Your Ref: OWPC18590
Our Ref: A/8/18/PL 26-01-2018
Please ask for:
Mrs A Gardner

Variation of condition 2 imposed under A/173/16/PL to read 'the development to be carried out in accordance with the following approved plans ADC 962/04 REVA, ADC962/13 & ADC962/14 relating to slight repositioning & change in size of building, revised position of rooflights on east, north & south elevations. This application affects the character & appearance of the Angmering Conservation Area.

Land Rear of 1 To 6 The Cottrells Angmering

A		Layout amended		10.11.17	
Rev		Description		Date	
Job Reference		Client			
New House The Cottrells Angmering, BN16 4AF		AM Homes Ltd			
Drawing Title		Drawing No		Rev	
Ground Floor Plan		ADC962/04		A	
Date	Scale	Dwg Size	Plot Style	Drawn	Checked
24.04.17	1:100	A3	ADC-red	TGS	AD

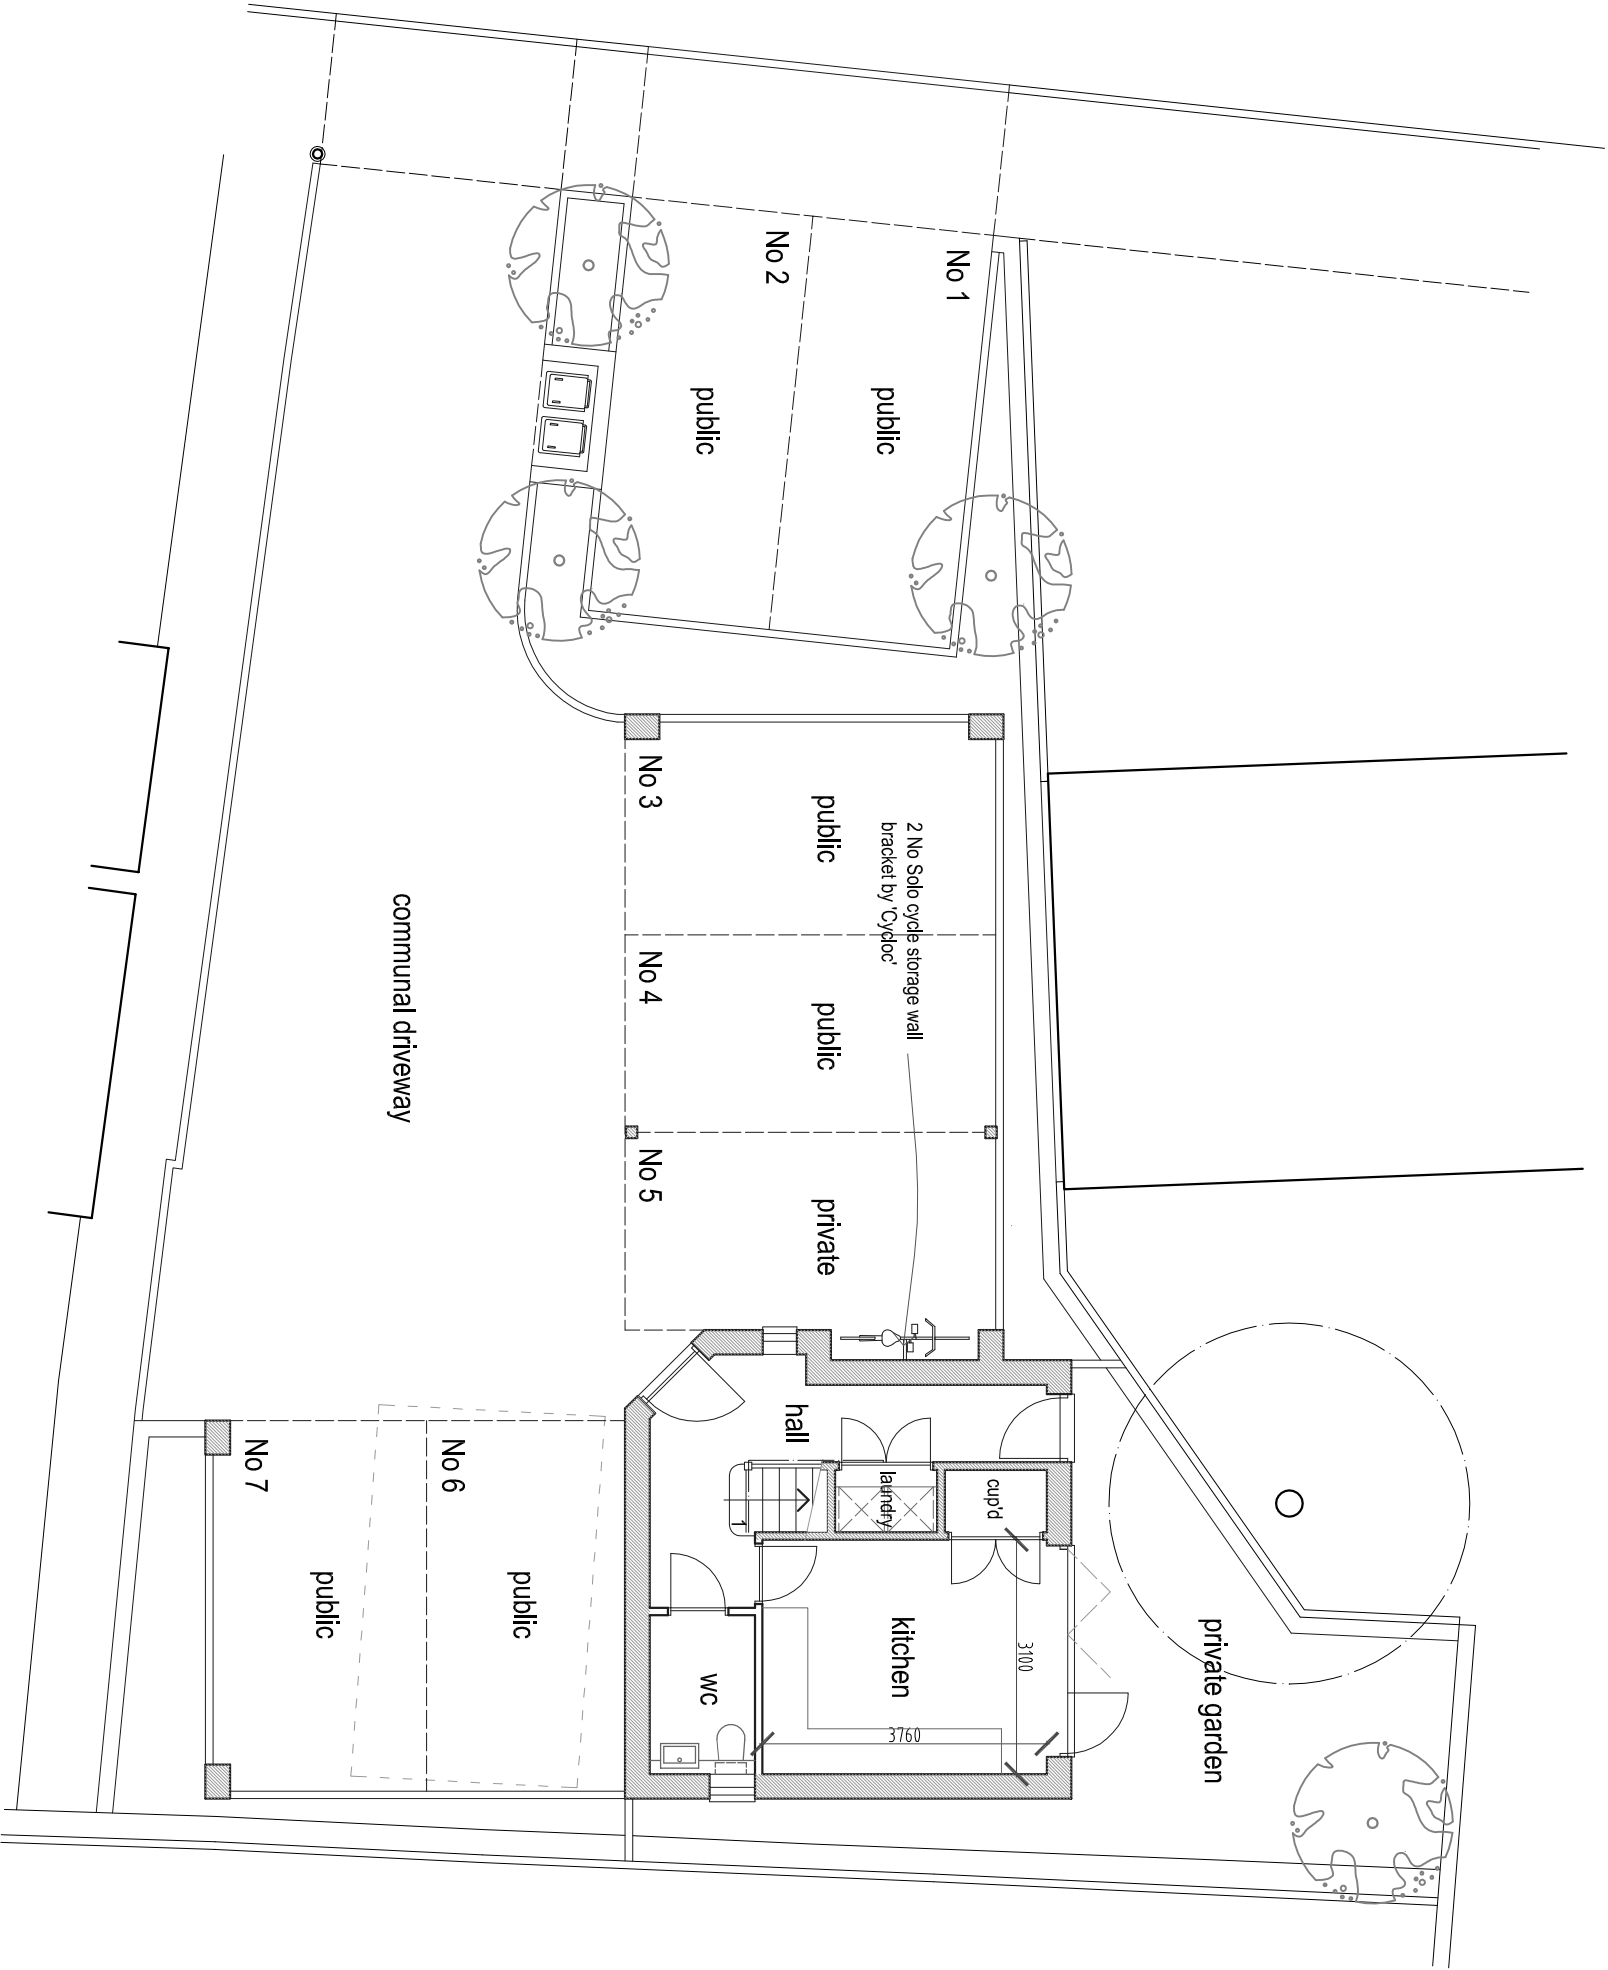
The application also refers to an alteration in the size of the building, the applicant refers to these as slight. As the submitted plans do not have all the measurements on we are unable to verify if these are actually wholly correct and the line of the wall and kerb marking the south boundary infringes on the shared alleyway which does not belong to the developer.

The plans are also incorrect as they show the alleyway running the length of the site whereas the alleyway terminates at the boundary with No.5. The Cottrells - this can be verified with the most recent land registry plans. This has to question if the plans have been drawn from the correct source.

Rev	Description	Date
Job Reference New House The Cottrells Angmering, BN16 4AF		
Client AM Homes Ltd		
Drawing Title First Floor Plan & Roof Plan		Drawing No ADC962/13
Date 16.01.18	Scale 1:100	Dwg Size A3
		Plot Style ADgrey.spl
		Drawn AD
		Checked AD

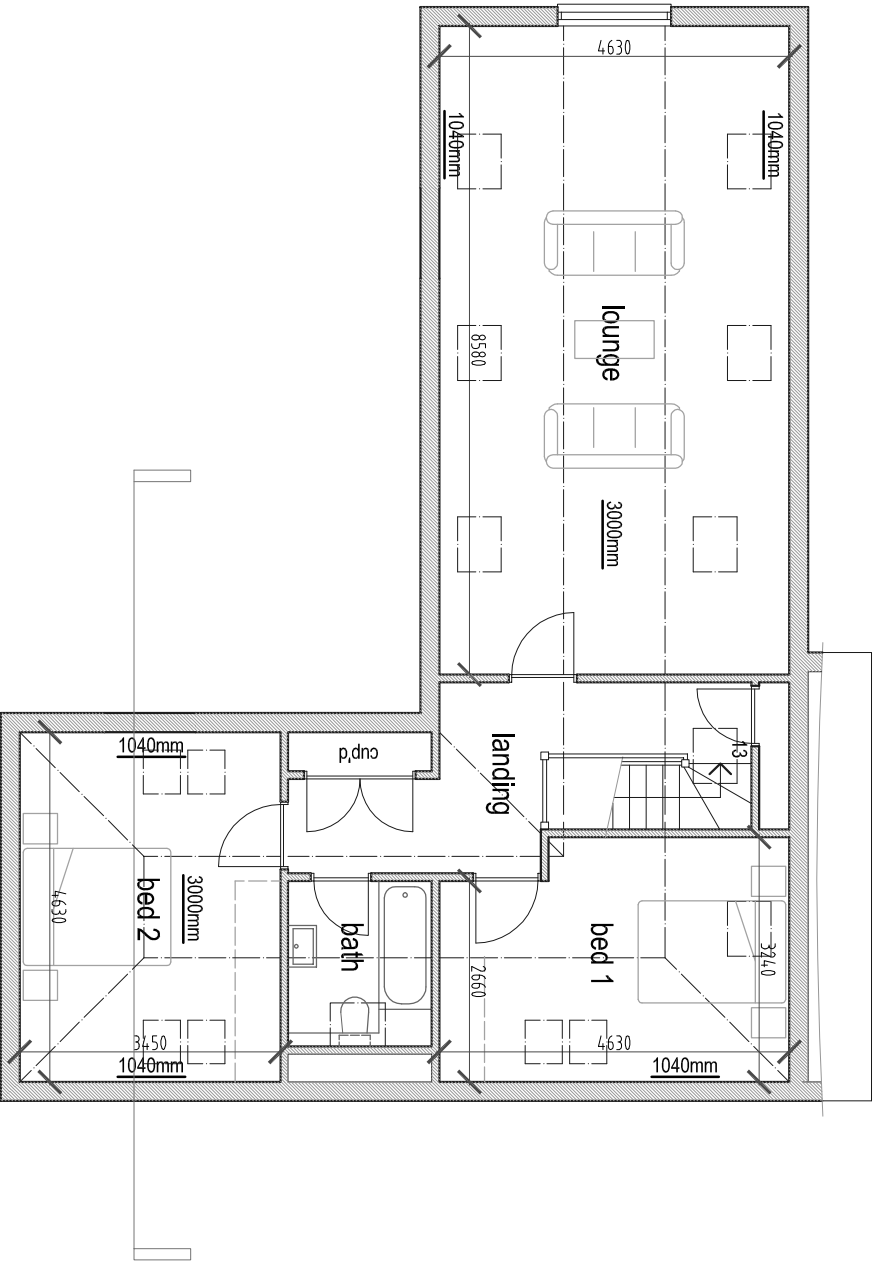
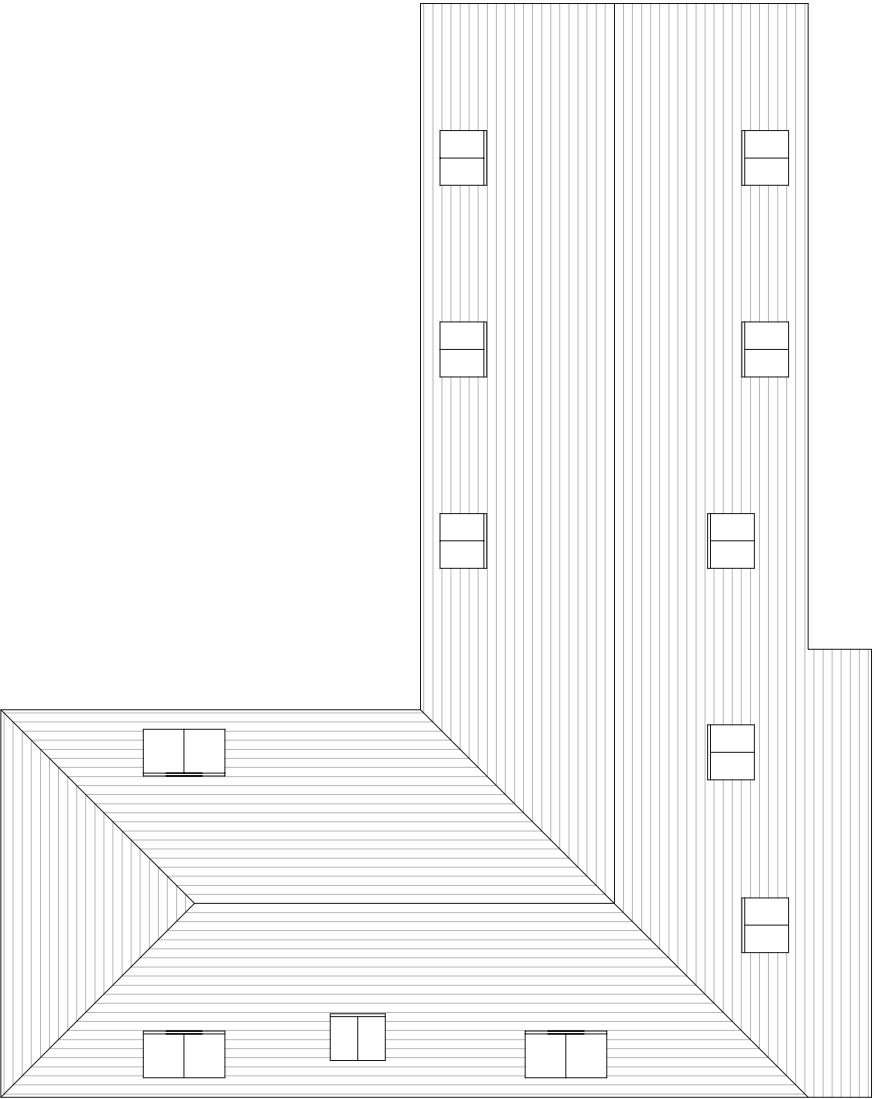
The current application shows the fully opening windows that have been installed instead of the escape roof lights approved by the committee. I am no expert but these installed windows appear in life to be 30% larger than those shown in the approved plans. The positioning and cill height of the windows mean they give a direct view into neighbouring properties. Surely this was never the committee's intention when approving the plans. My understanding was that the approved roof lights would not have opened except in an emergency.

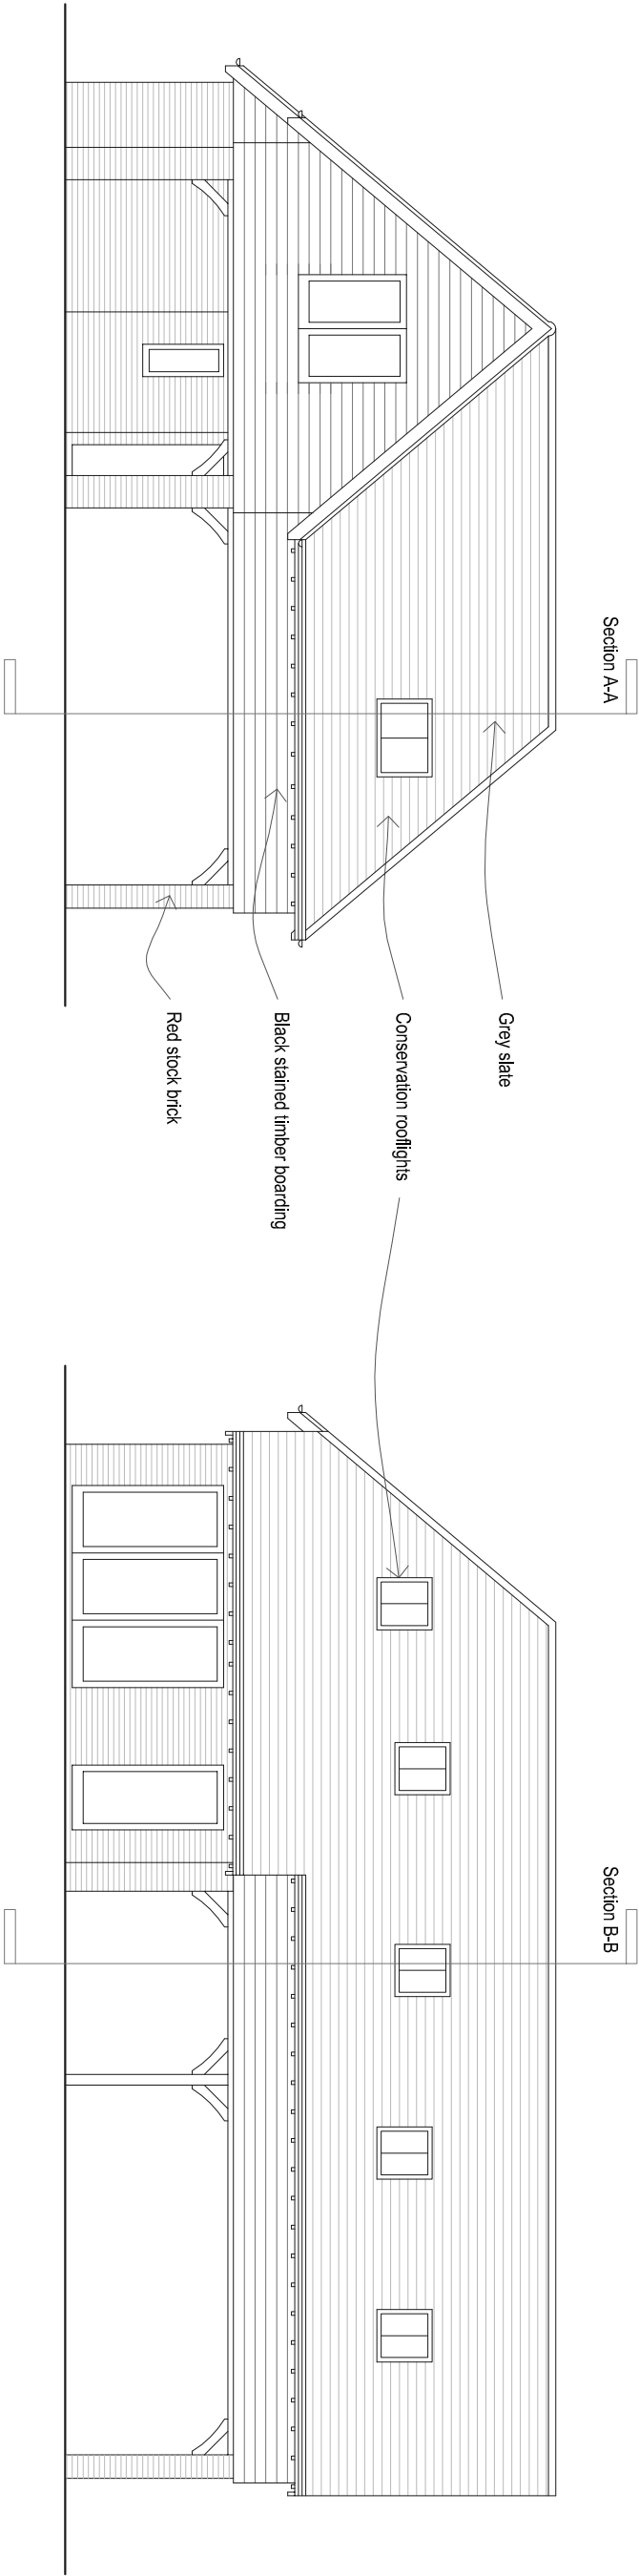
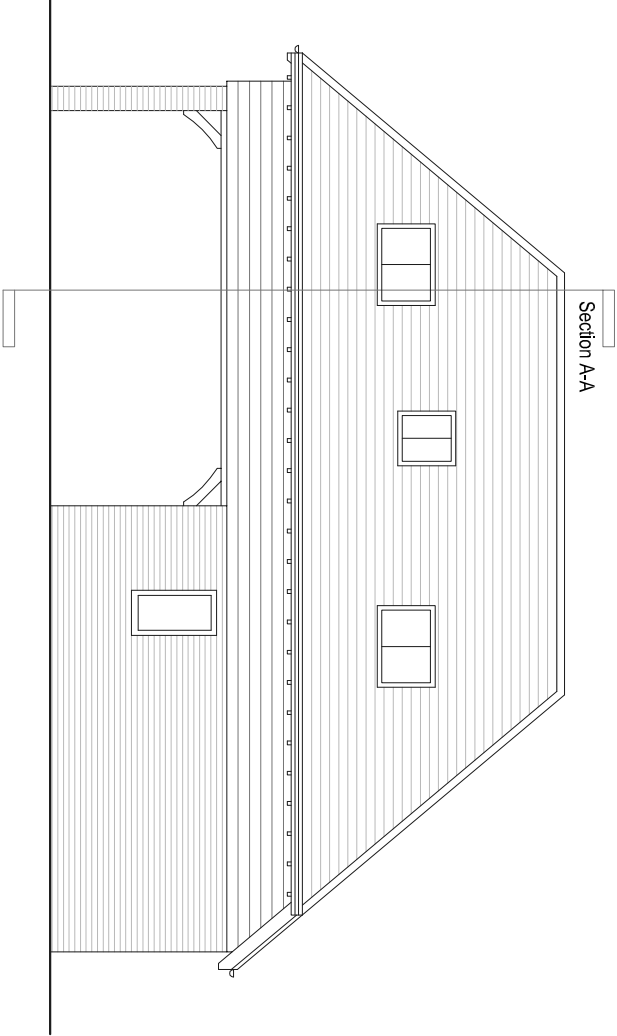
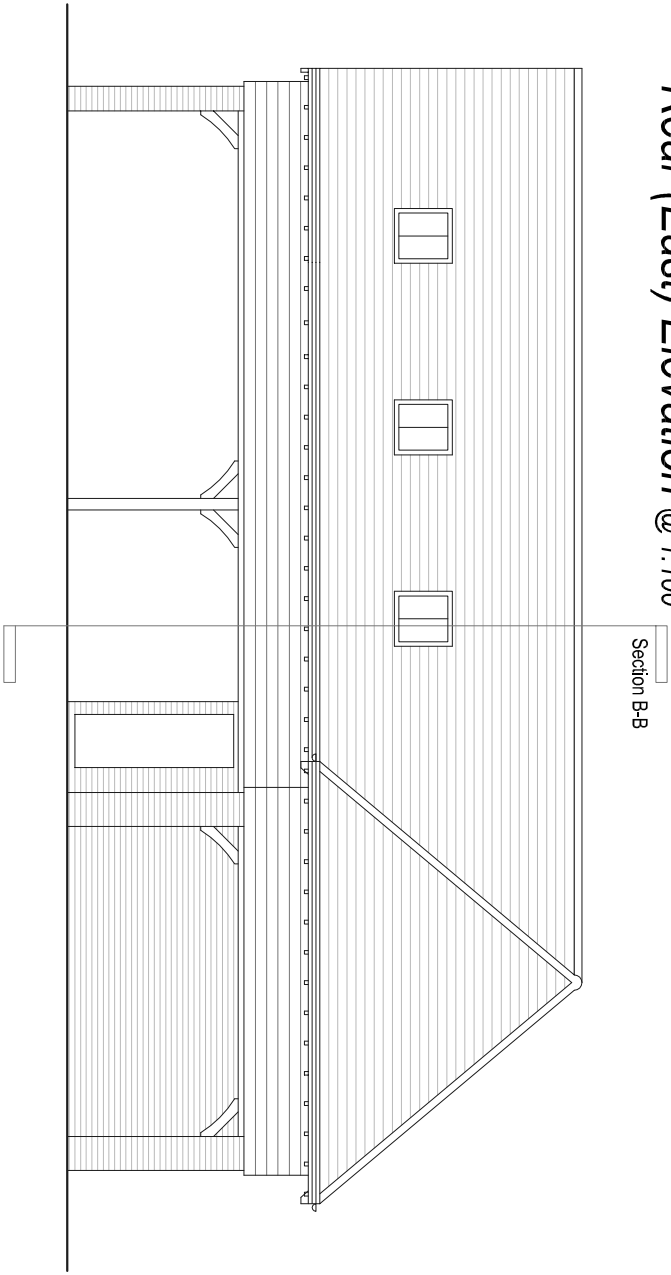
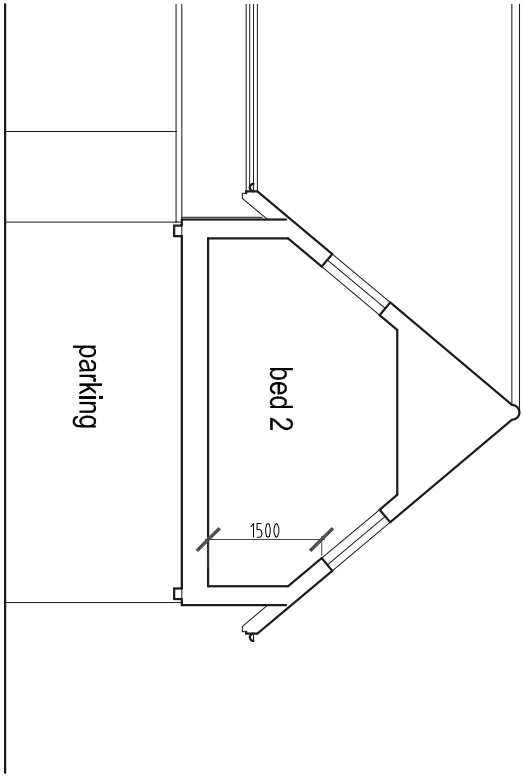
I object to this application because the size and positioning of the windows cause material harm to local residents. The application refers to slight changes in sizes however the overbearing nature of the building changes the character of the neighbourhood.

I also ask the committee to act to ensure the position, height and type of windows only

allow light into the dwelling and not a view out. This could be achieved by installing fixed glazing with an increased sill height of at least 1.8m or even using obscure glass. The large fully opening conventional window on the west elevation does not overlook any property, it provides light, ventilation and a view. This window could be fitted with appropriate equipment to be used as a fire escape.
